Lot 3A NORTHCREST CENTER FILING NO. 1A SITE DEVELOPMENT PLAN EL PASO COUNTY, COLORADO.

DRAWING NO. COVER
SITE DEVELOPMENT PLAN

PCD FILE NUMBER: PPR-21-036

DRAWING NO.  
1  
SPECIAL USE PLAN

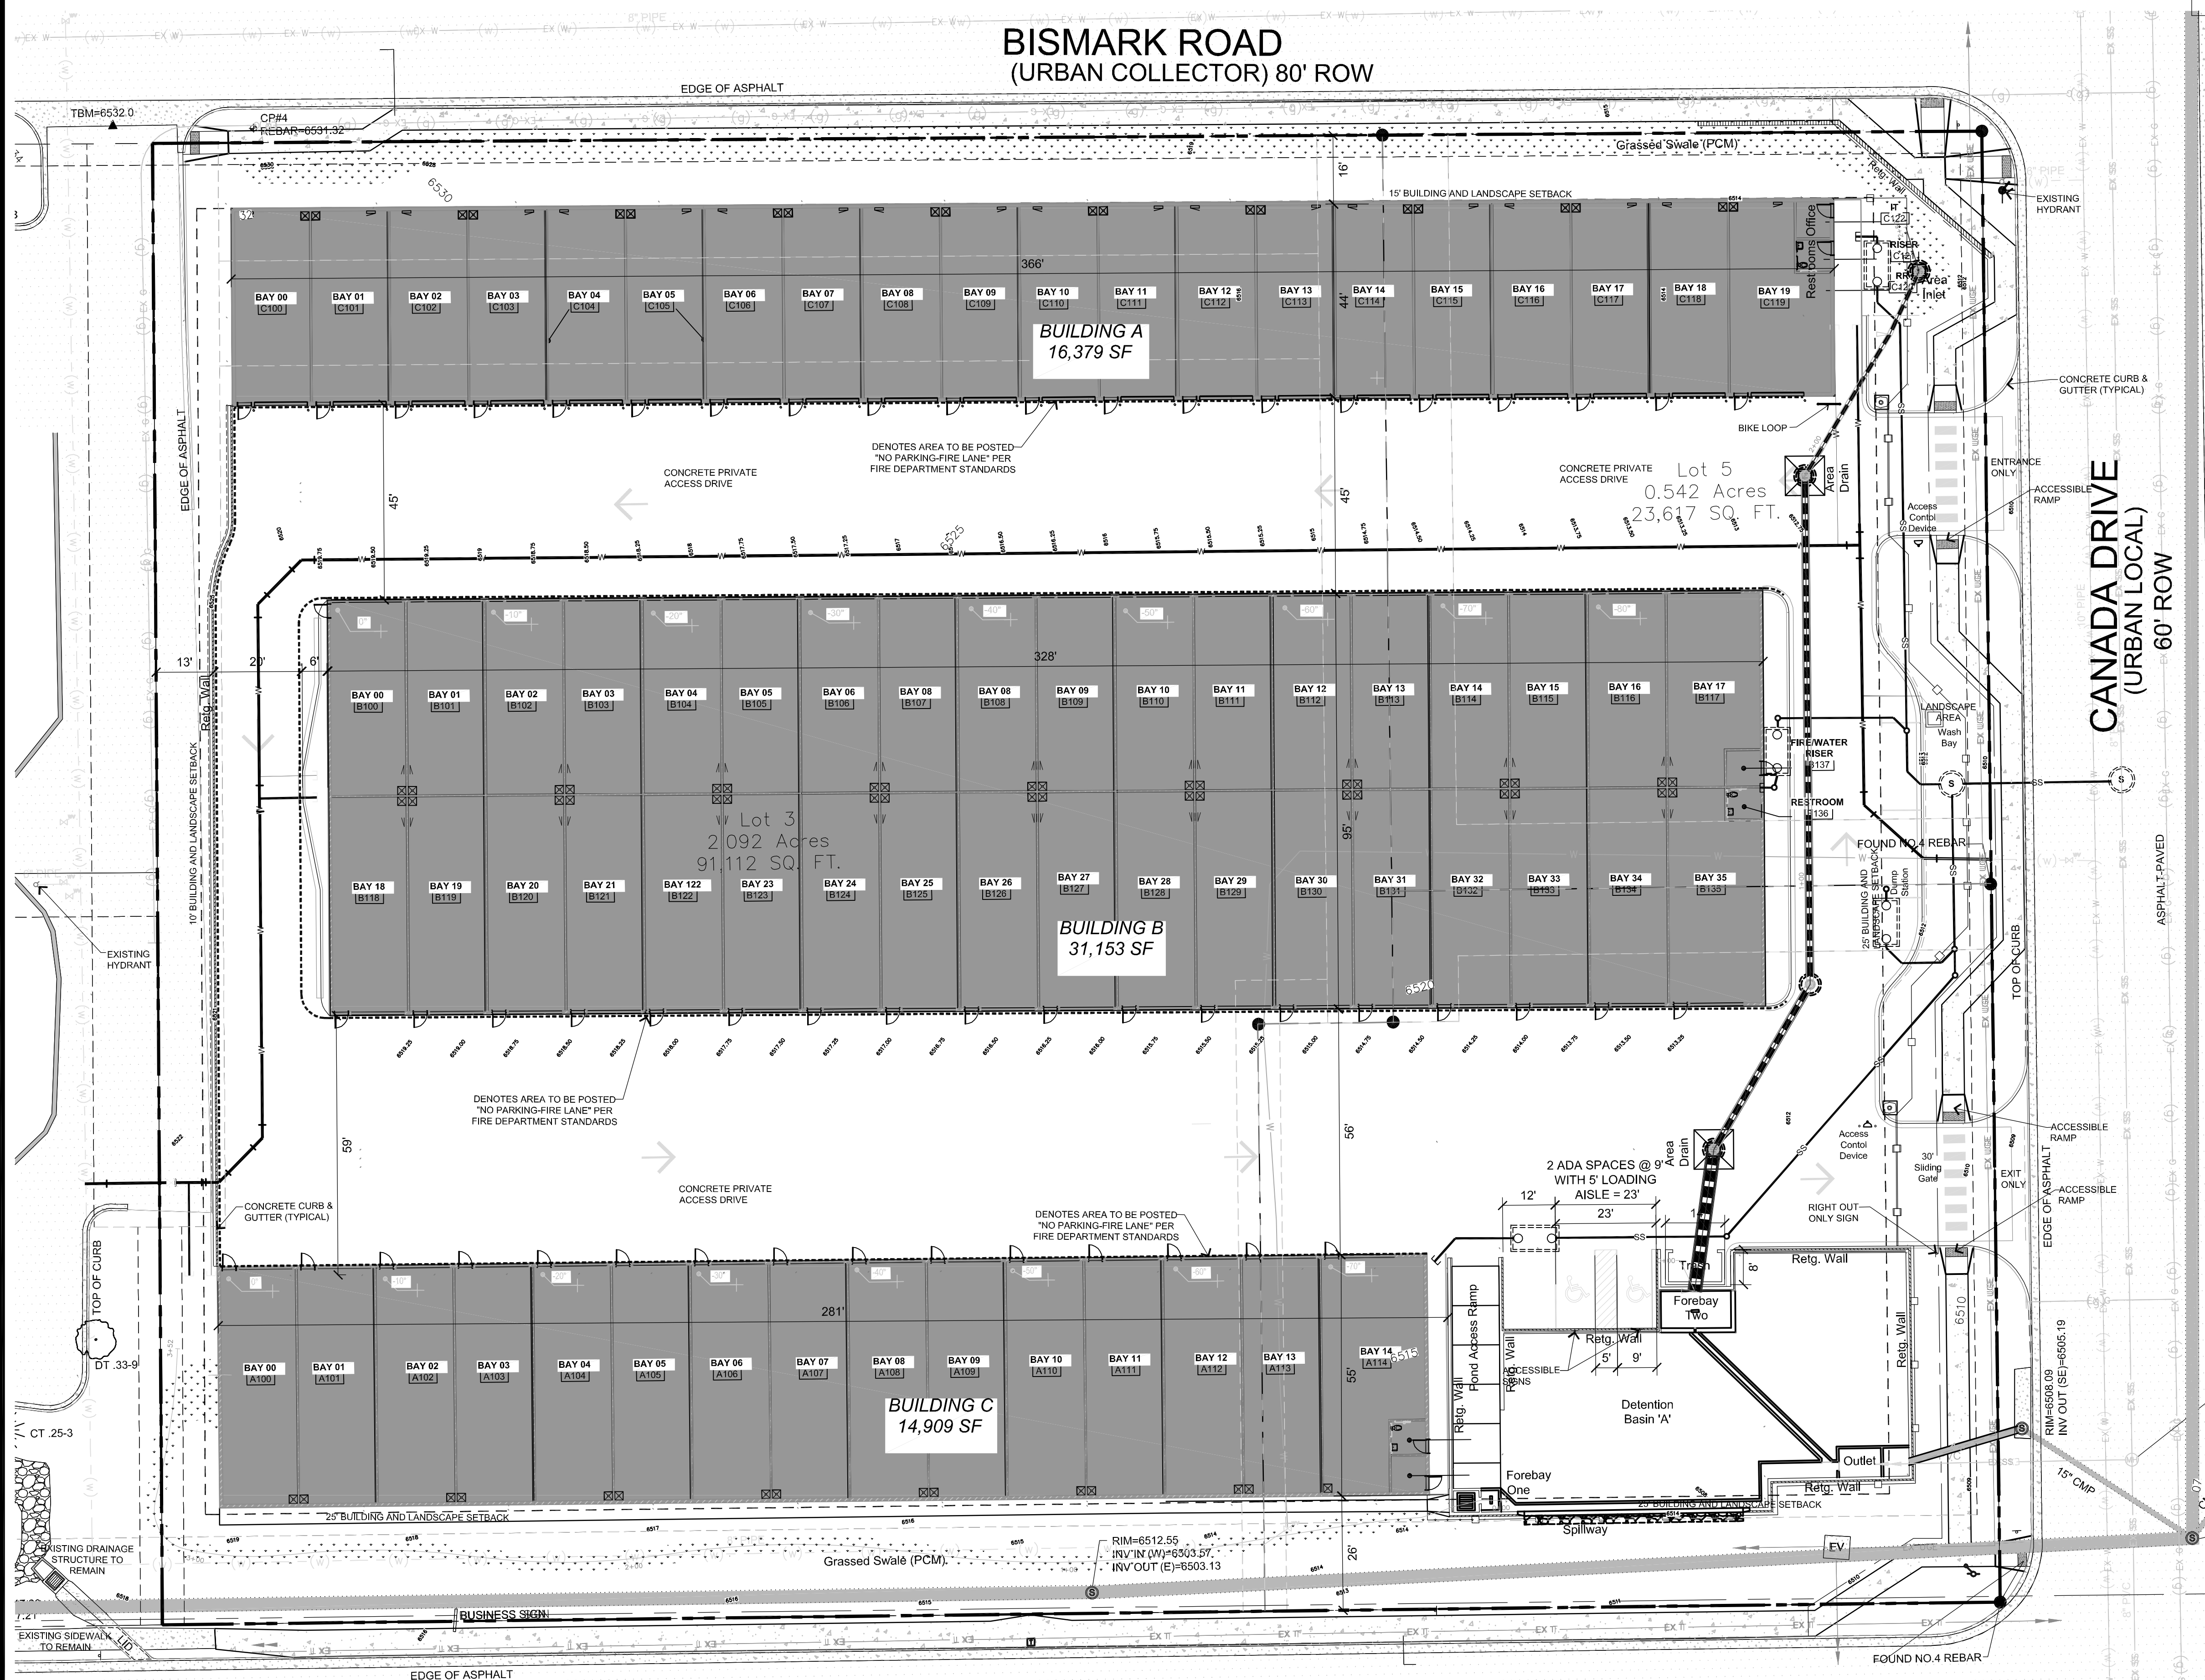
Add missing EPC Standard detail for ped ramps and crosspans SD-25, SD-25, SD-4, SD-41 and SD-42. Recommend moving all SD to last sheet

Add note to SDP

tax schedule no.:	5332309006	EPC ASR record states 3.25 acres. Please review.
area	3.32ac	
ex zone	CC	
proposed zone	CC	
ex use	CC	
proposed use	commercial center	
master plan	Falcon/Peyton Small Area Plan	
development schedule	Phase 2	
area	3.32ac	
proposed use	commercial center	
bldg area	63,239sf	
max. bldg height	45'	40 feet
prop. bldg height	20'	
bldg setbacks		
front	25'	25 feet
side	15'	
rear	15'	
%lot coverage		
bldgs	45% (63,239sf)	
impervious	38% (53,546sf)	
landscaping	17% (24,611sf)	
use	STORAGE	
bldg area ratio	63,239sf	
required (incl h/c)	1 space for the office 2 (incl 1h/c) 2 (incl 1h/c)	
provided		
	1 space per 100 units plus 1 space per employee
